PRE-HEARING STAFF ANALYSIS

Rezoning Petition No. 2004-95

Property Owner: Christ Lutheran Church

Request: R-3, single family residential to INST (CD), institutional conditional district

SITE PLAN

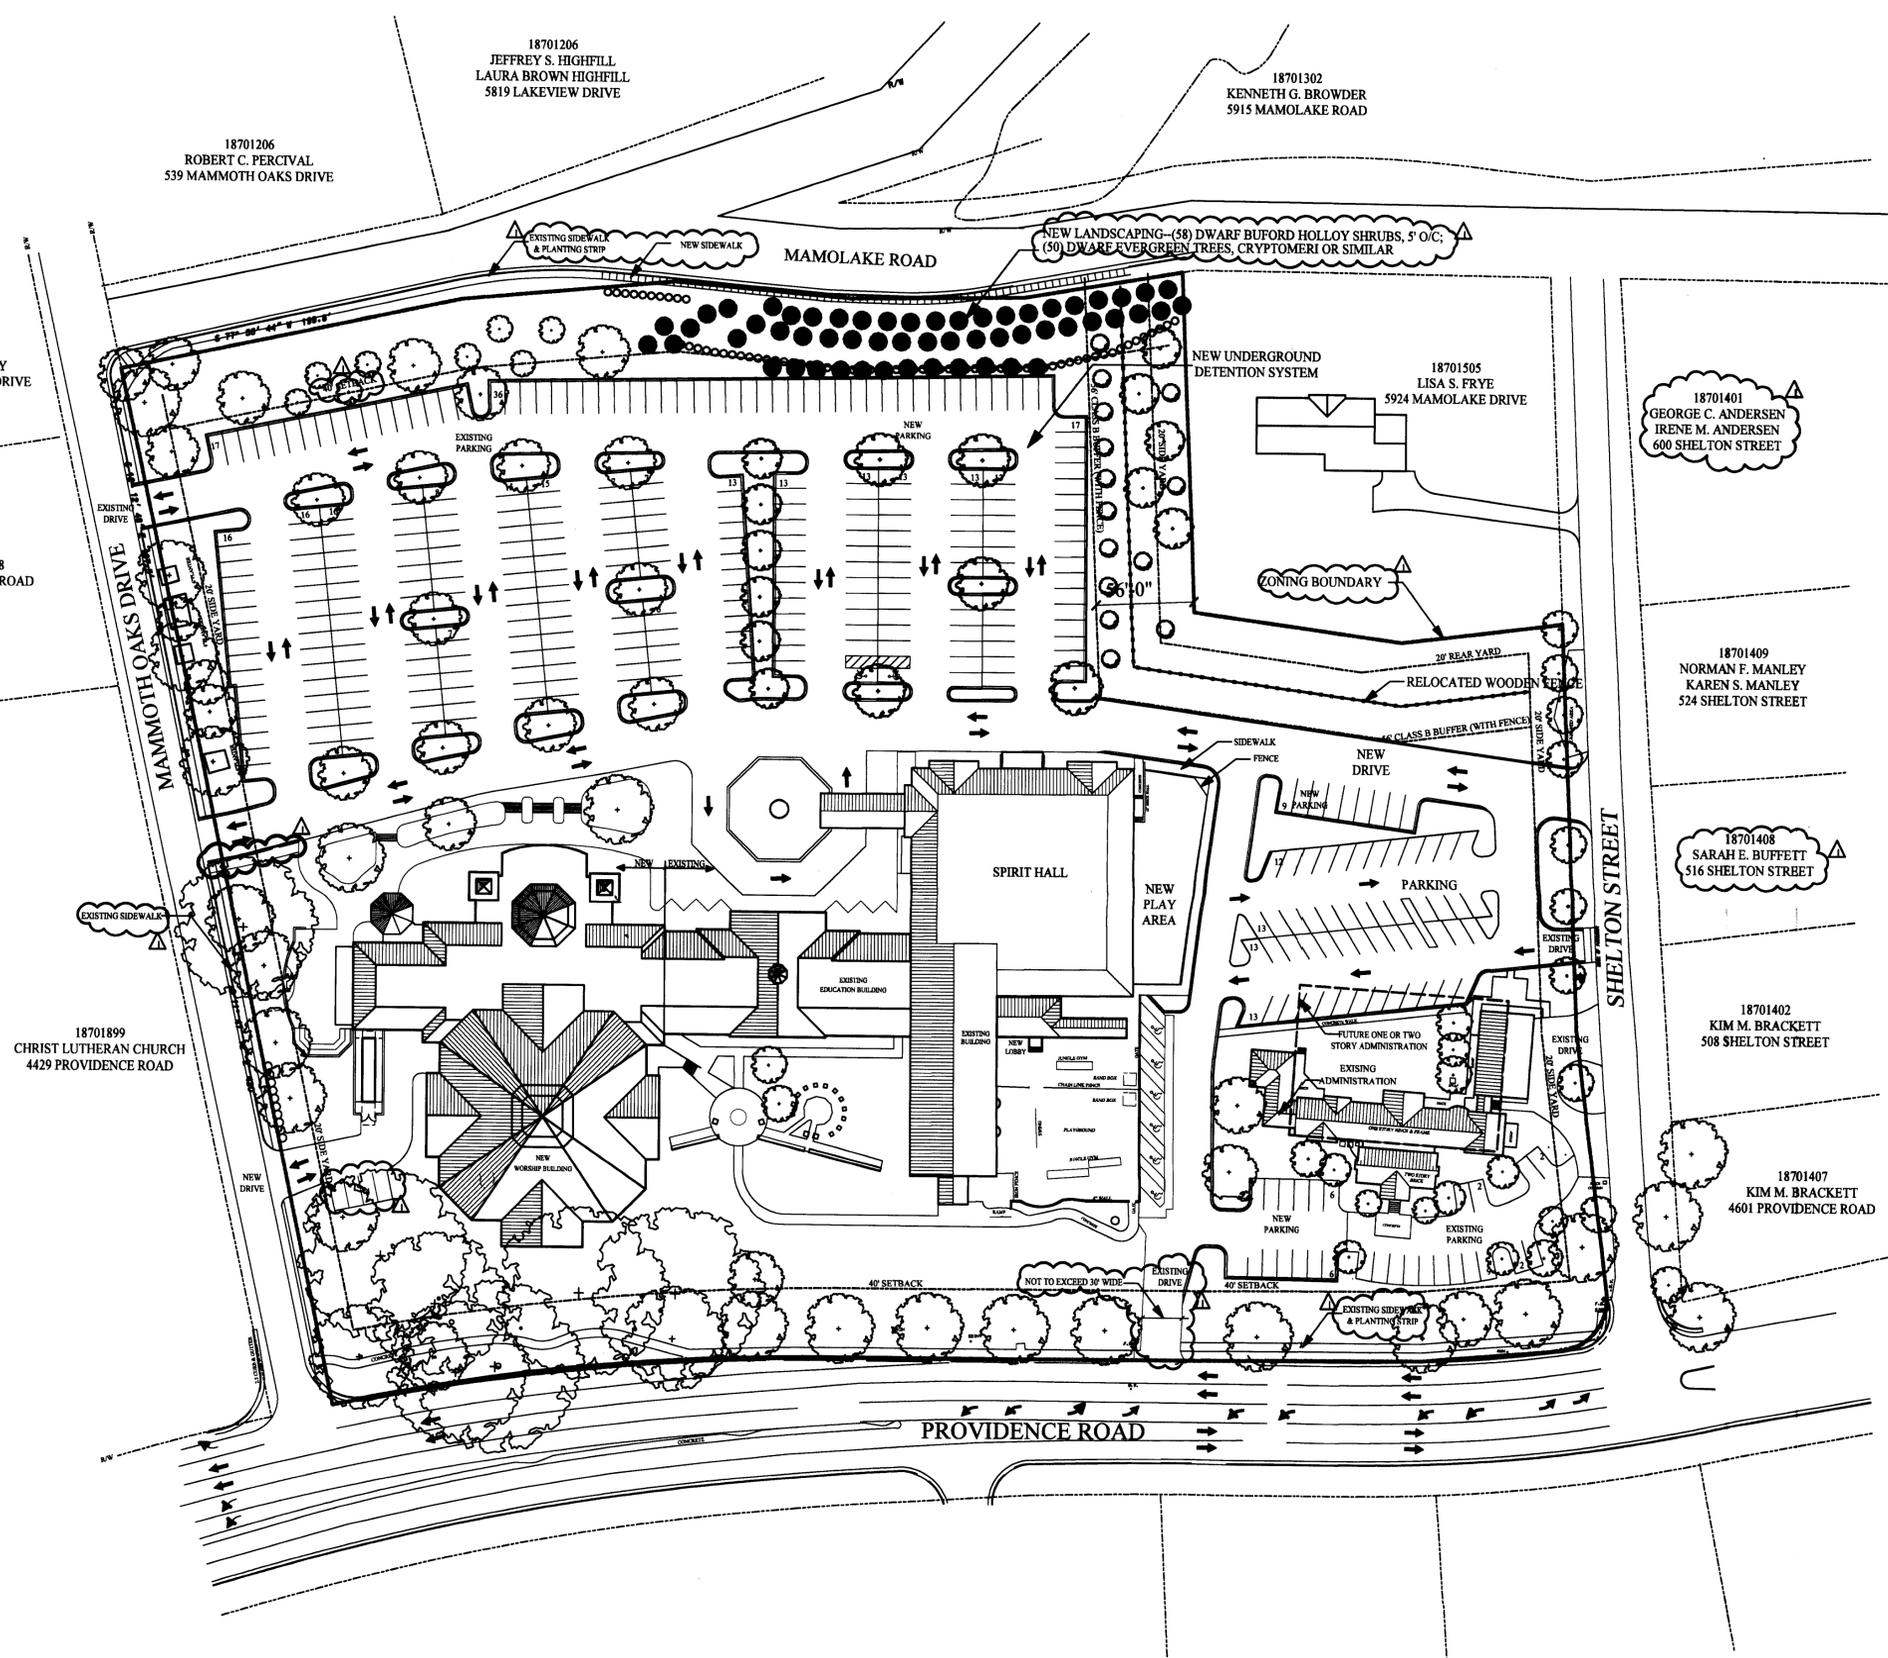
- The existing one-way driveway connection to Providence Road should be shown having a maximum width of 30 feet and perpendicular to street. As shown the driveway is too wide and will not be approved. The parking lot drive aisle that is proposed to connect to this driveway should be marked to prevent vehicles from turning left toward Providence Road.

- The transitional setbacks should be shown on the site plan.
- The 15% tree save area should be indicated.
- 5-foot sidewalks and 6-foot planting strips should be provided along all streets.
- The proposed zoning should be noted as Inst (CD) not "I."
- The site plan shows 9.98 acres and the rezoning application indicates 9.84 acres. This should be clarified.
